Rezoning Transportation Analysis

Petition Number: 2021-079

From: Brandon Brezeale, PE

Date	Description
08-02-2021	First Review (WB)
08-23-2021	Second Review (WB)
09-17-2021	Third Review (KP)
10-18-2021	Fourth Review (PDM)

DRAWING NO.: **RZ-01**

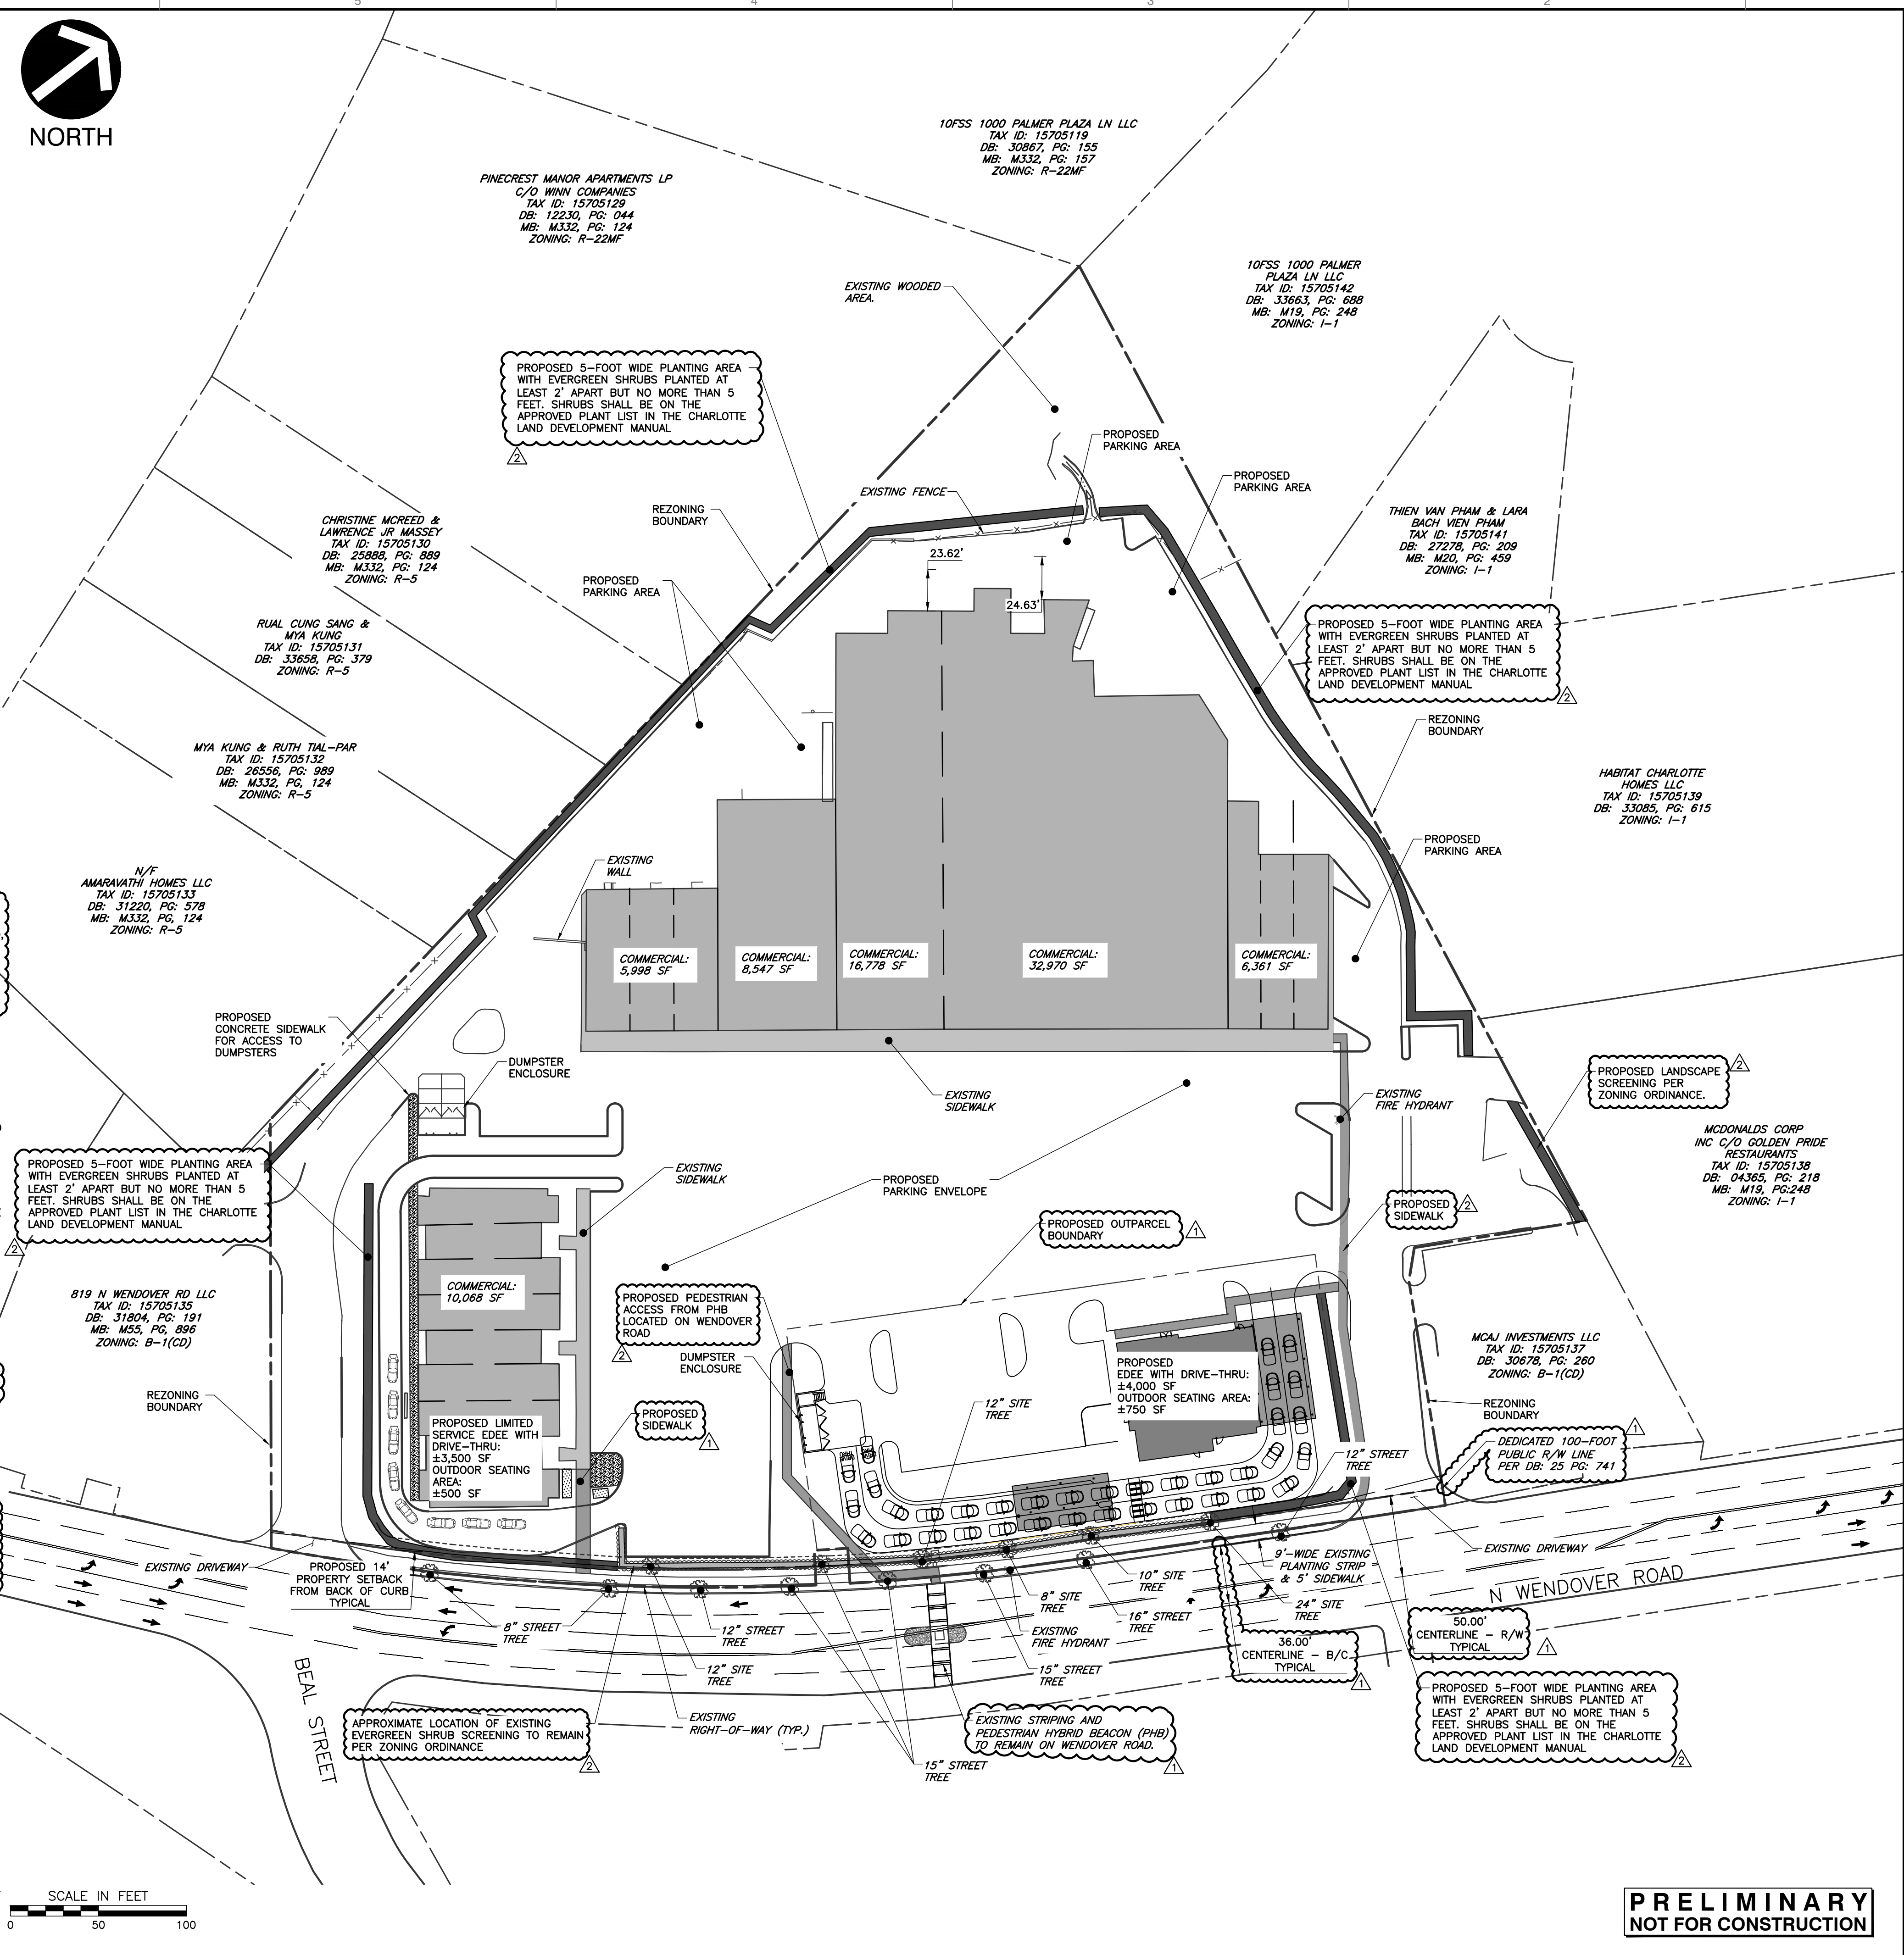
4. **Outstanding Comment from 08-02-2021:** Site plan and conditional note(s) revisions are needed to commit to installing a 12' multi-use path with an 8' planting strip along the site's frontage of Wendover Road to meet the Charlotte BIKES Policy.
